Appeal Decision

Appeal Ref: APP/R5510/W/22/3301303

Nursery, Lawn Road, Uxbridge UB8 2TJ

- The appeal is made under section 78 of the Town and Country Planning Act 1990 against a failure to give notice within the prescribed period of a decision on an application for planning permission
 - The appeal is made by RBMF Developers Ltd against London Borough of Hillingdon.
 - The application Ref 75251/APP/2021/4446, is dated 6 December 2021.
 - The development proposed is Redevelopment/refurbishment of nursery building (Use class E) including demolition of annex and rear extension. Erection of a three storey building comprising 1 x 1 bed, 1 x 2 bed residential units (Use class C3).
-

Proposed Site Plan

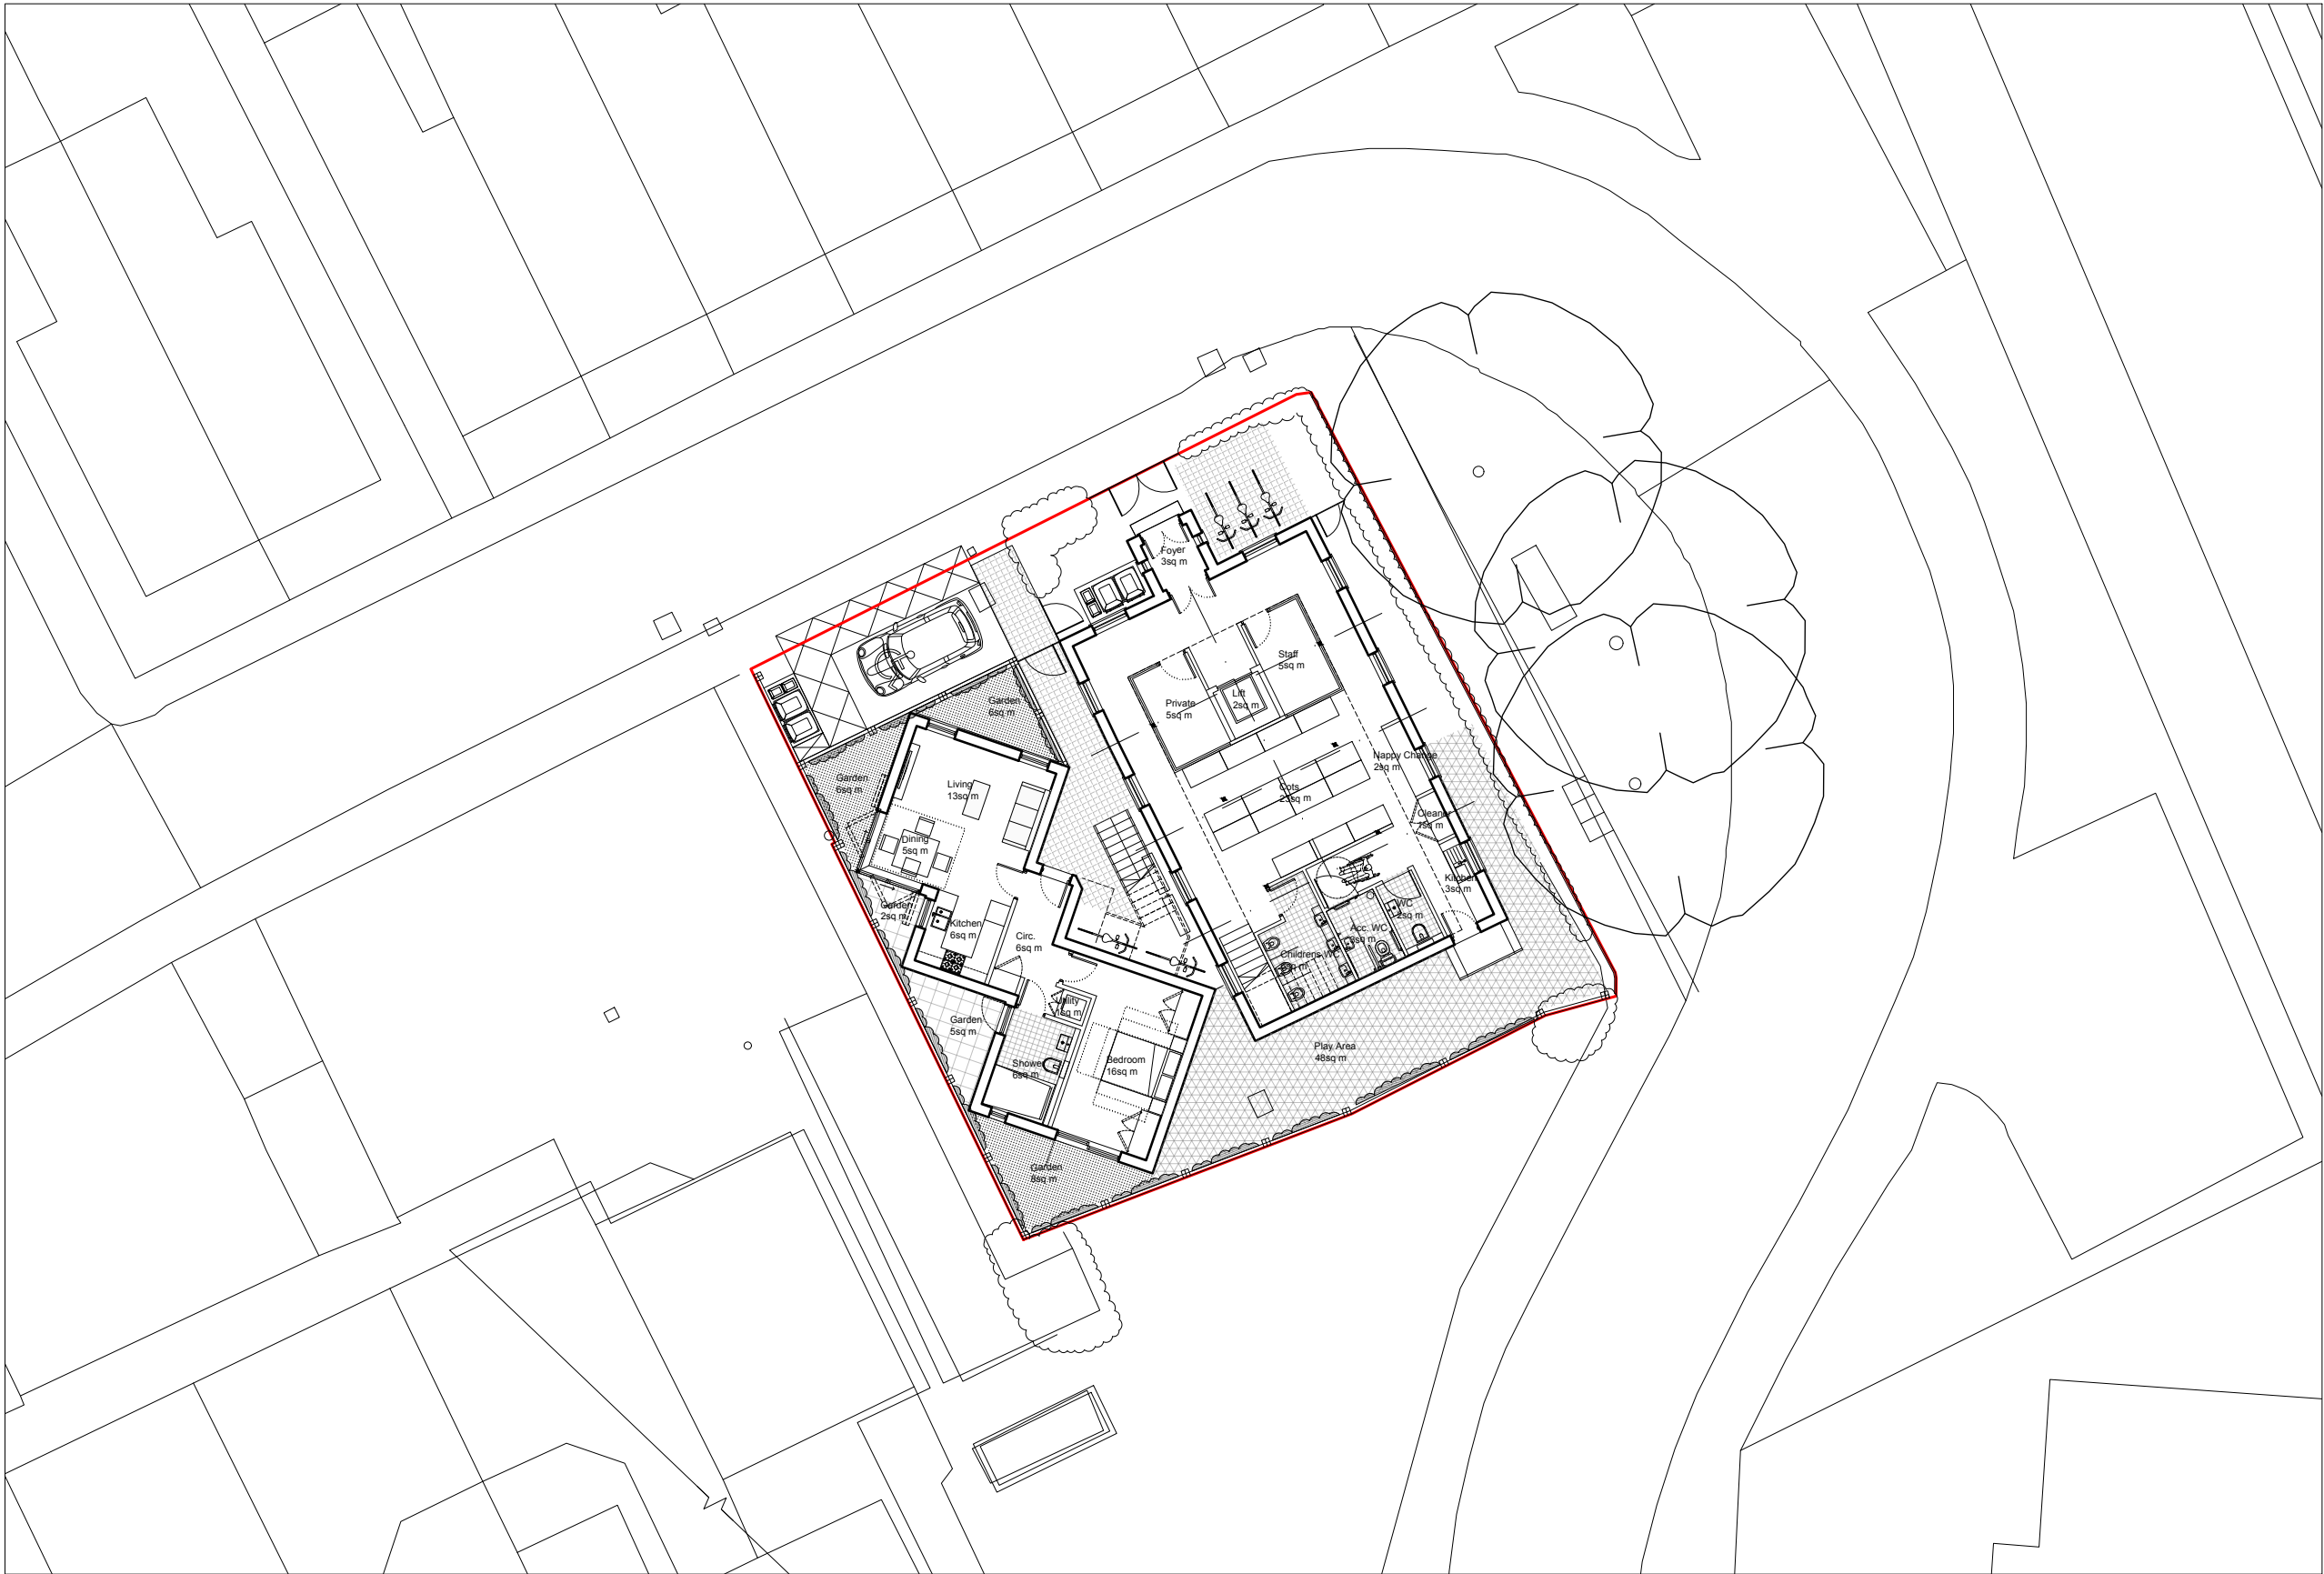
8. The angular nature of the design of the proposed building, relative to Lawns Road, would create some sense of space from the front façade of the Chapel. However, the rear block, including the external staircase, would be very close to the side elevation. In combination with the height proposed, the resulting scale of building and positioning would fail to harmonise with the Chapel in the street scene.

15. The elevated nature of the terrace would allow its users to look down into the first floor rooms of Nos. 11, 13, 15, 17, 19 and 21 Lawn Road. In this regard, the terrace would appear unduly invasive from these neighbouring properties. The location of planters and pulling the terrace back from the edge would not, in my view, prevent this, due to the small depth of the planters.

21. The proposed disabled parking space would be positioned parallel to the road and footway to the front. It is unclear from the information before me how the manoeuvring of the vehicle into the space would work in practice, particularly if vehicles were parked on the opposite side of the road. I recognise that this matter was not raised by the Highways Authority. However, it was raised by the Planning Officer, and from the evidence before me I can not be satisfied that there would not be significant manoeuvring onto the footway itself. This would be prejudicial to pedestrian safety and highway safety as vehicles travel around the corner adjacent to the Chapel. Given the increased vulnerability of young children leaving or arriving at the Nursery, it is not appropriate to address this matter by way of a condition were I minded to allow the appeal.

22. The proposal indicates two cycle parking spaces below the stairs within the site grounds. Due to the height of the staircase rising above the bike access area, I consider that there would be sufficient space to manoeuvre the bikes in and out. Precise details, including how they would be secured, could be required by way of a condition were I minded to allow the appeal.

Drawing
Demolition Plan

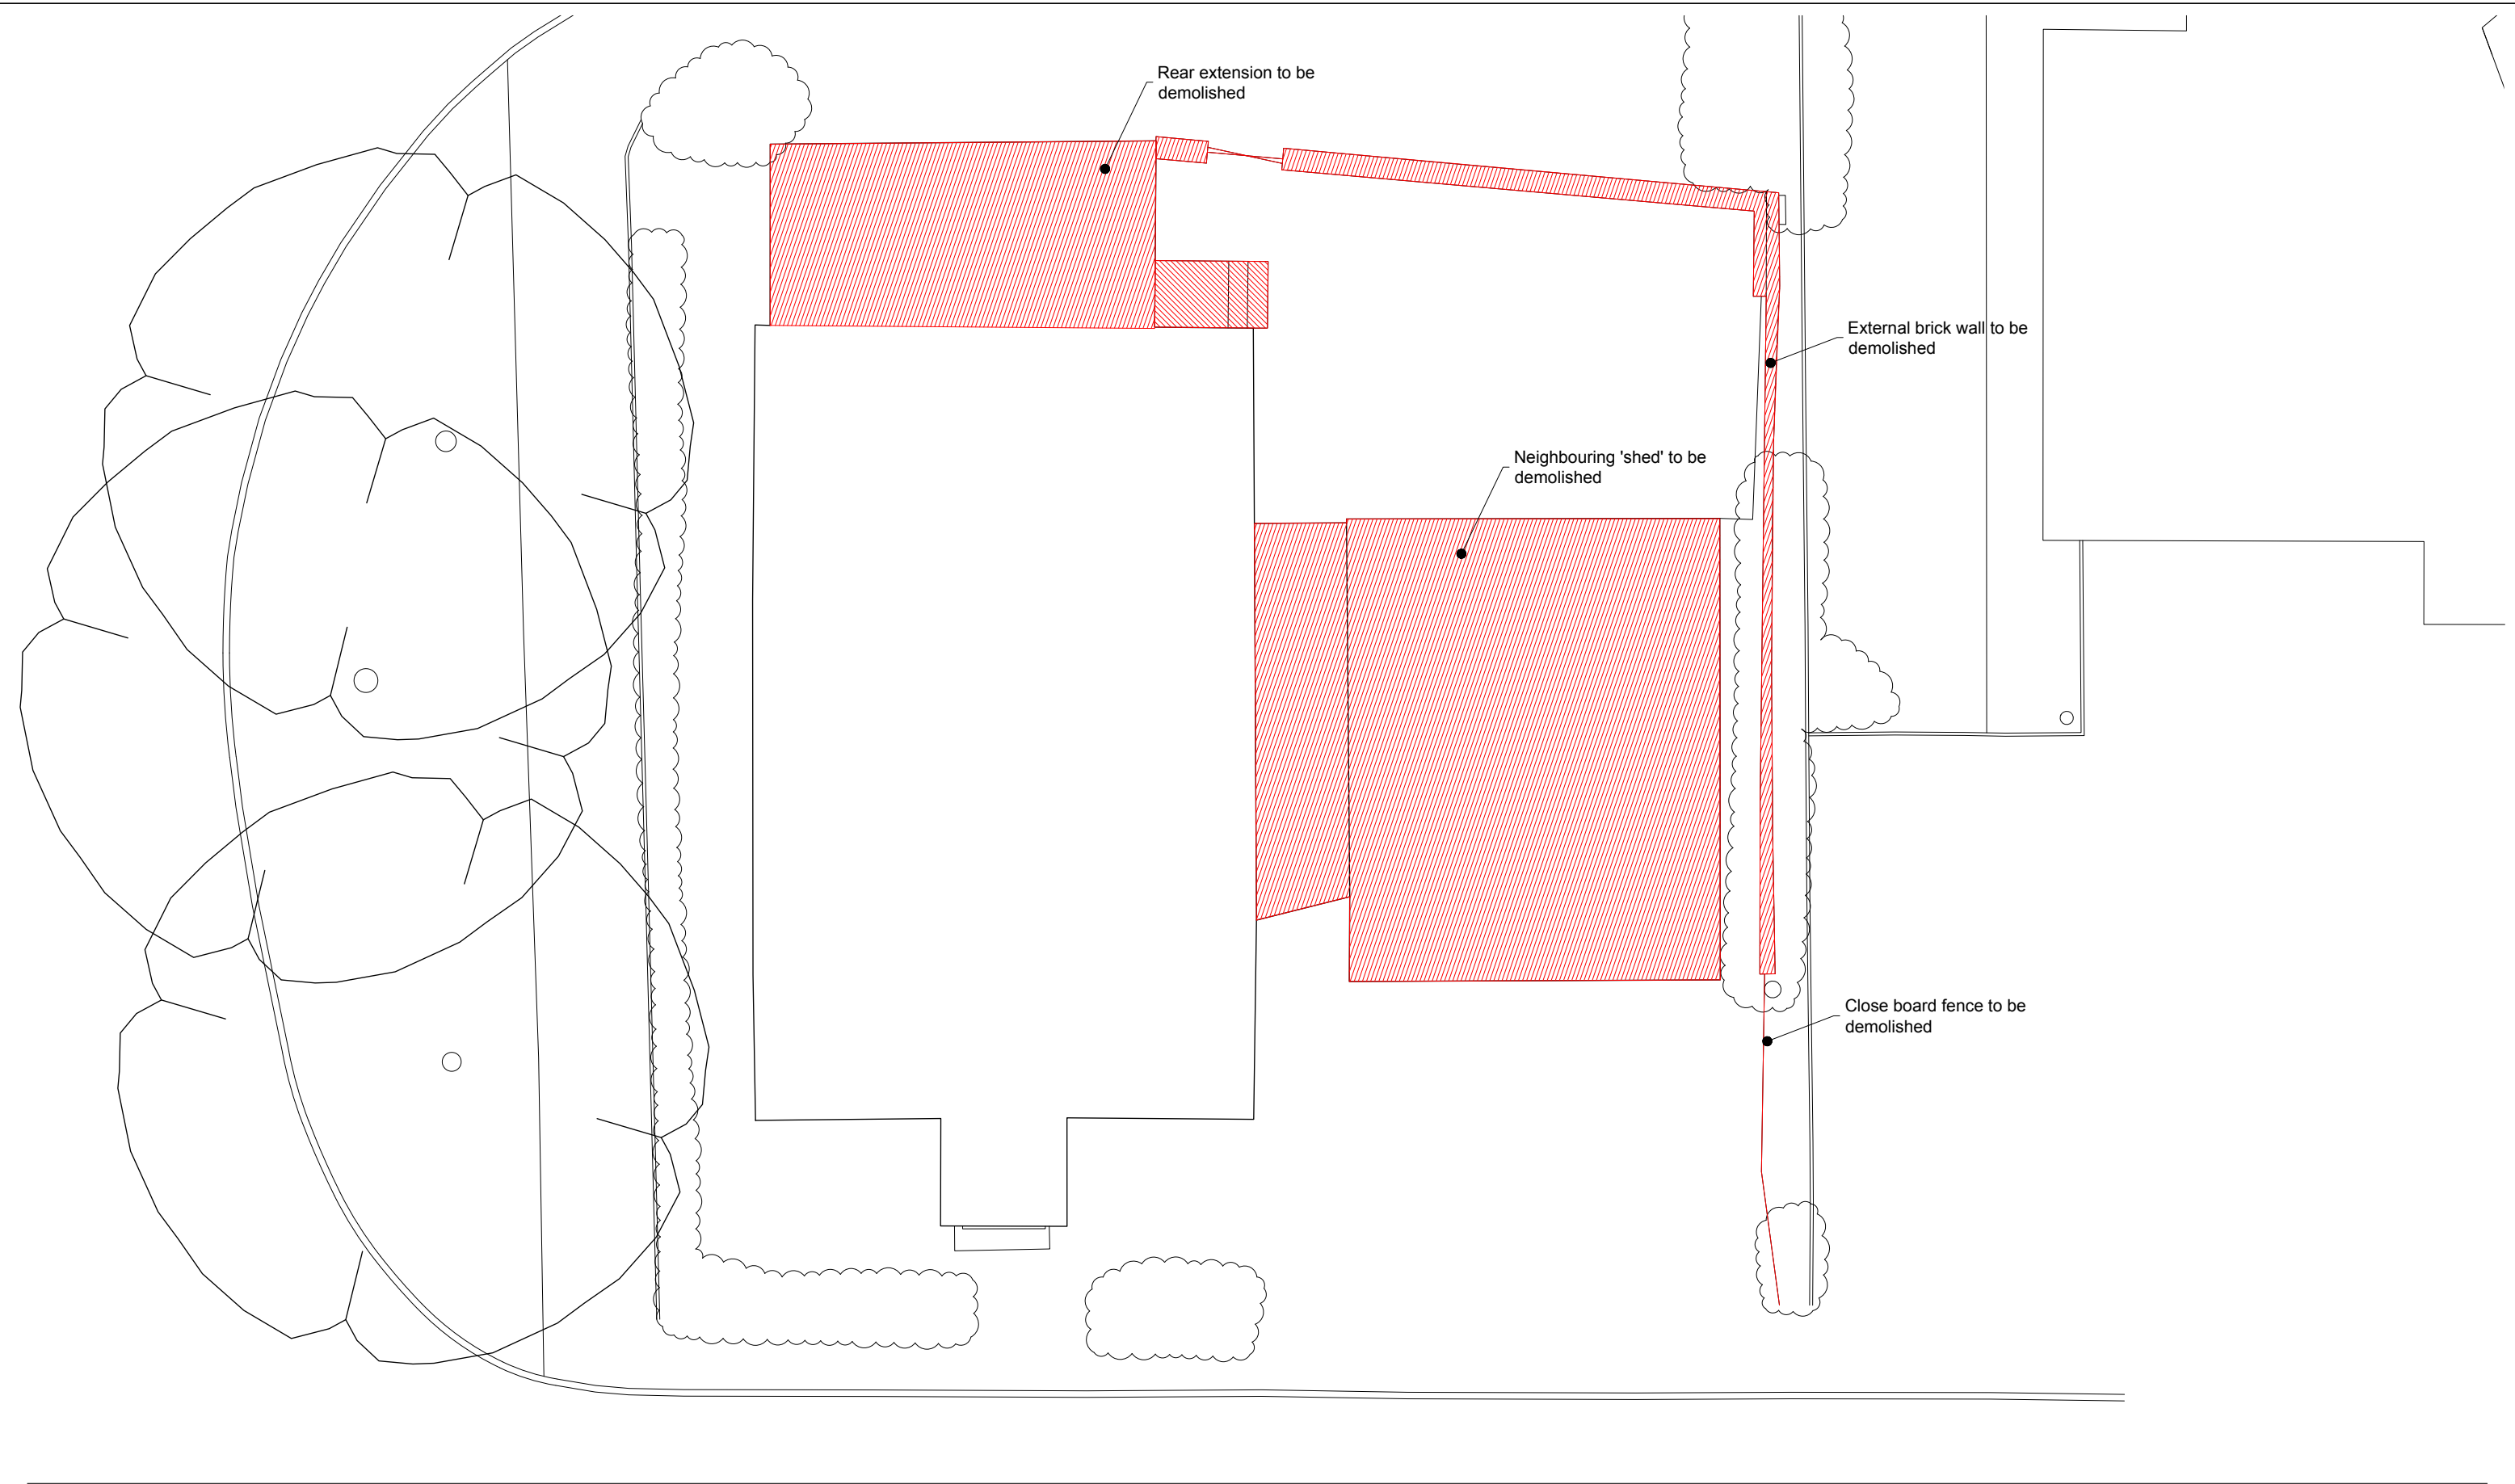
7. The existing metal clad addition is a somewhat utilitarian structure that does not make a positive contribution to the character of the CA. However, it is small and is set back from the front façade of the Chapel, ensuring it is subservient to, and reflects the simplicity of, the Chapel. As such, it is not an unduly dominant feature. This contrasts with the appeal proposal, which would be aligned with the main front façade of the Chapel and would be taller than it.

12. The proposal would refurbish the Chapel, with benefits to the Nursery use, and it would result in the removal of the metal clad structure. However, the proposed replacement building would cause greater harm to the character and appearance of this part of the CA than the existing structure, due to the subservient scale and positioning of the existing structure. Moreover, it has not been demonstrated that the appeal scheme as designed, and with the harm I have identified, is the only way of renovating the existing Chapel building.
